CITY OF ALBUQUERQUE

RE: 5046 Valle Del Sol Rd. NW
Grading and Drainage Plan
Engineer's Stamp Date: 09/07/18
Hydrology File: J11D038

Based upon the information provided in your submittal received 09/10/2018, the Grading Plan is **not** approved for Building Permit. The following comments need to be addressed for approval of the above referenced project:

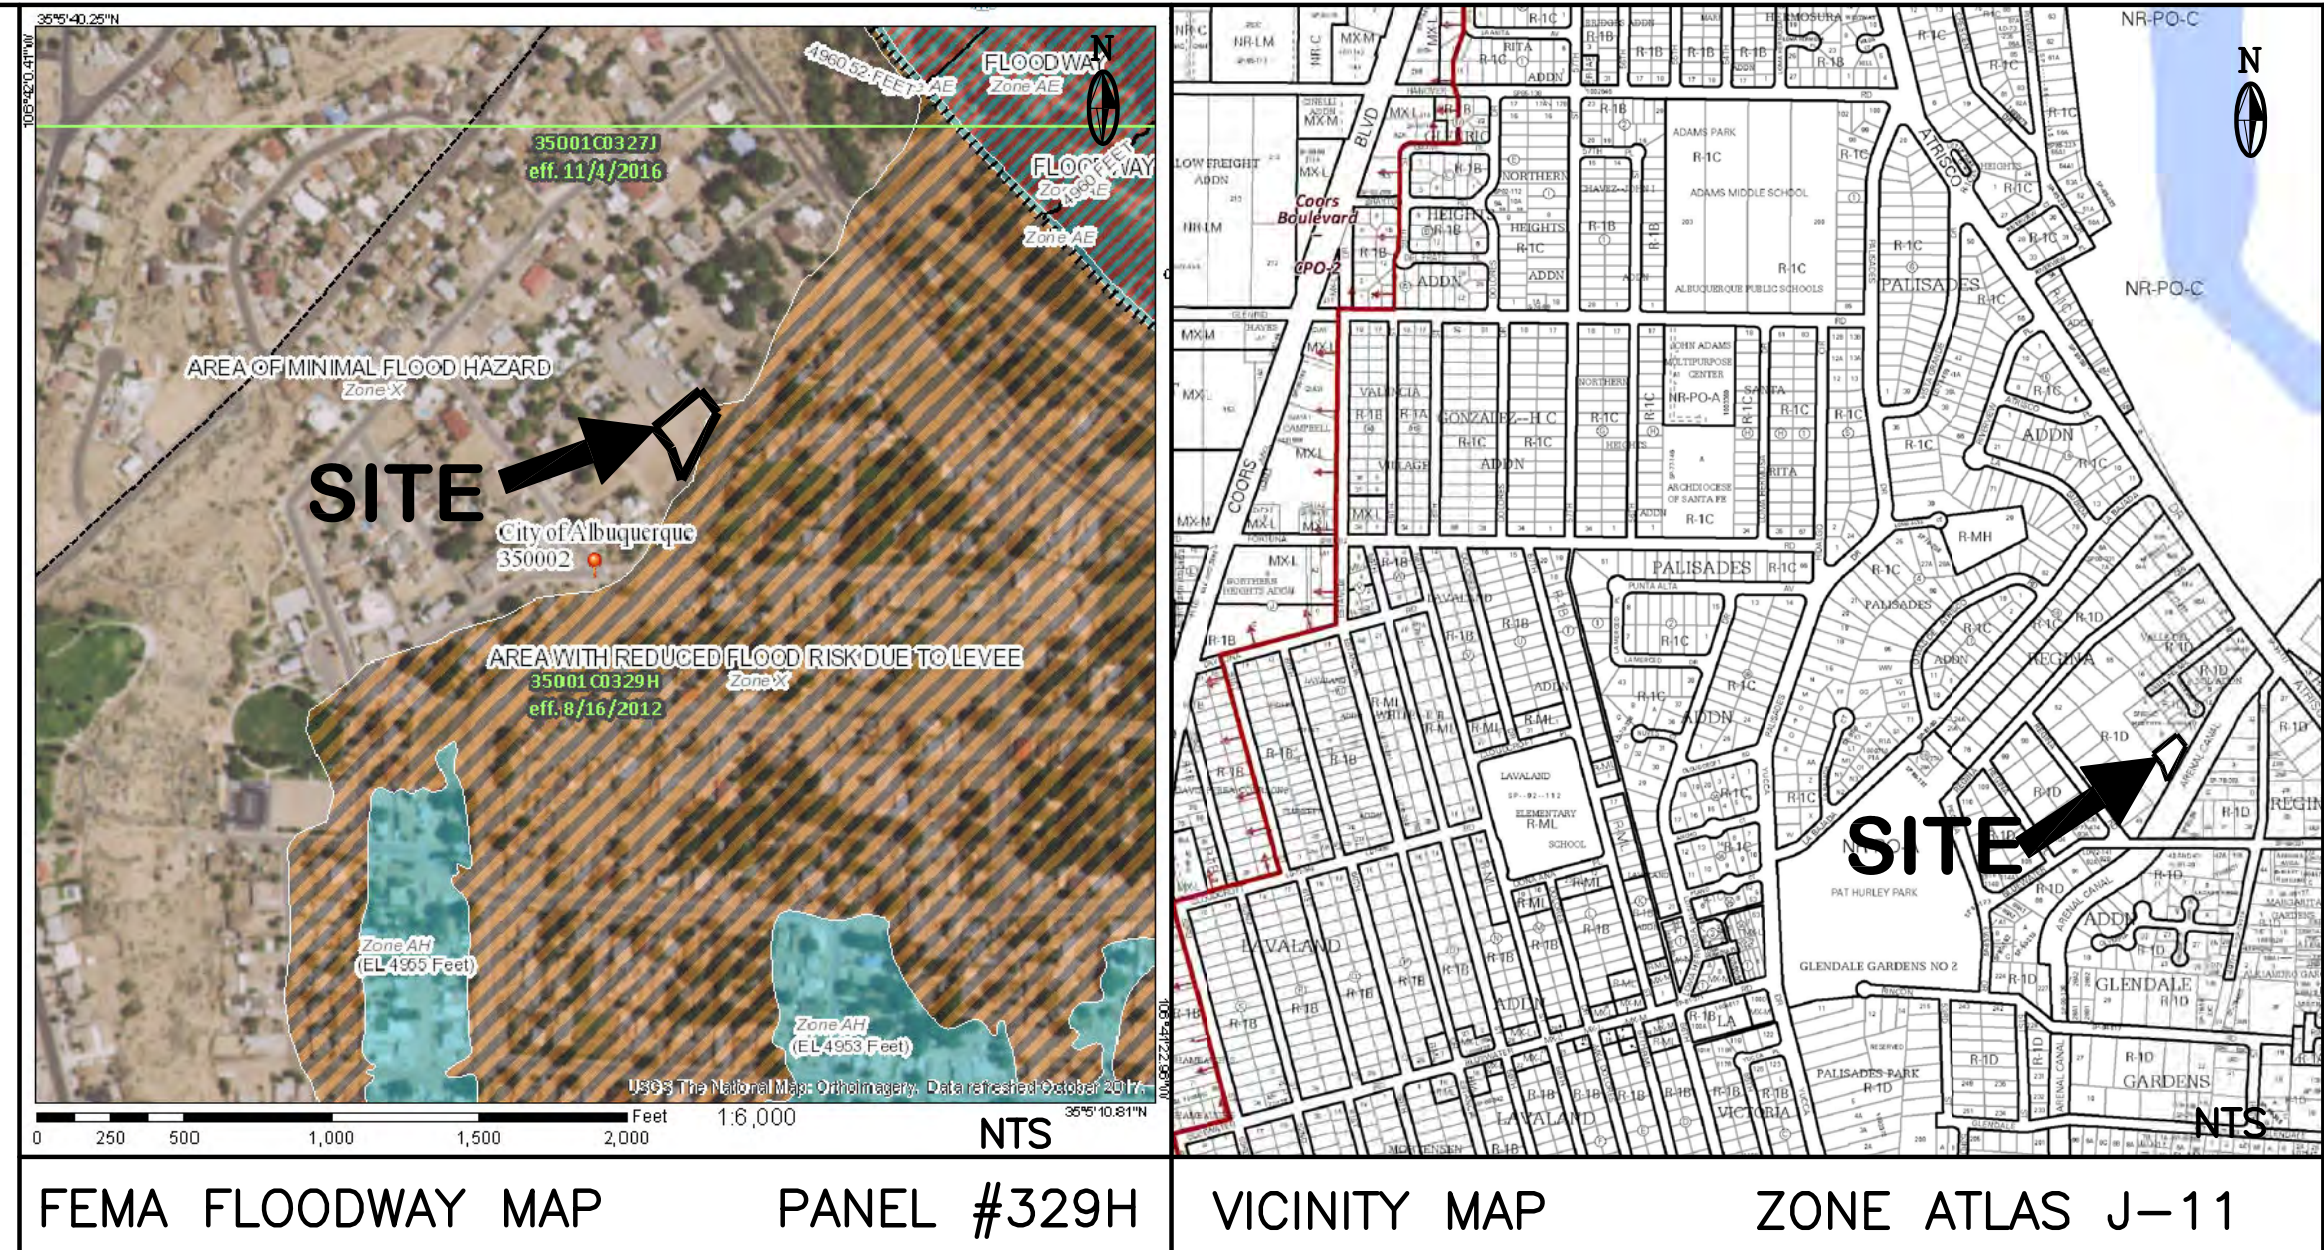
1. Currently the design does not follow the Flat Grading Scheme outlined in the DPM. Please follow Chapter 22 Section 5.G (Flat Grading Scheme). The following conditions must be applied to the site:

- a. The maximum percent impervious of the lot and the contributing area may not be greater than 45%.
 - b. Pad elevation shall be a minimum of one (1) foot above the 100 year 10-day storm water surface elevation.

- c. The flow between the front yard and back yard cannot be obstructed. The storm water must be allowed to equalize to the same level between the front yard and back yard.

- d. A permanent perimeter wall or barrier around the development is required to contain the 100 year 24 hour storm developed runoff.
 - e. The high point of the street should be four inches above the 100 year 10-day storm water surface elevation.

2. Also a retention pond is required. The required volume = (3.67 in. X impervious area / (12in/ft)). The location with elevation of pond and the calculation of both the required and actual volume needs to be shown on the Grading Plan.

3. Please place gravel and slope the hammer head on this project's property at least. Transportation may want the entire hammer head built. This is for the Fire Department. The area of this graveled hammer head needs to be included in the Type C soil in the calculations.
